MEMO

FROM:
Mark Everson
Arboricultural Officer.
37945

Planning Application. WA/61/ 09/T Prune out dead wood and reduce by 45% One Oak tree due to excessive shading at cedar Cottage and overhanging Woodlea Cottage Wandley's Lane.

SKETCH PLAN

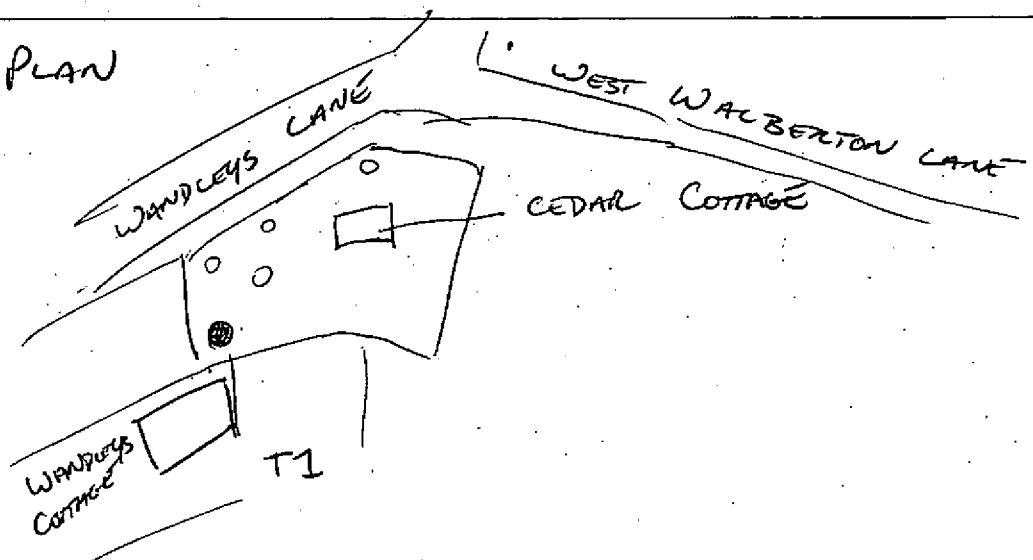
The work specified in the application is very drastic and will result in a very unsightly tree the main structure being reduced to a limited number of very bare boughs which will produce nothing but "Witches Brooms "on the ends of the boughs where the pruning takes place.

There is no statement in the application from a qualified tree surgeon regarding the work or why it has been applied for, apart from the fact that it overhangs the neighbour's property. To cut that amount back to the boundary would render the tree very imbalanced and from the amenity point of view very out of keeping with the rest of the trees in the area.

I suggest that the maximum reduction of any thing on this tree should be 15% from the ends of the branch work and this would have to be undertaken by a qualified Arborist under the supervision of the Arboricultural Officer.
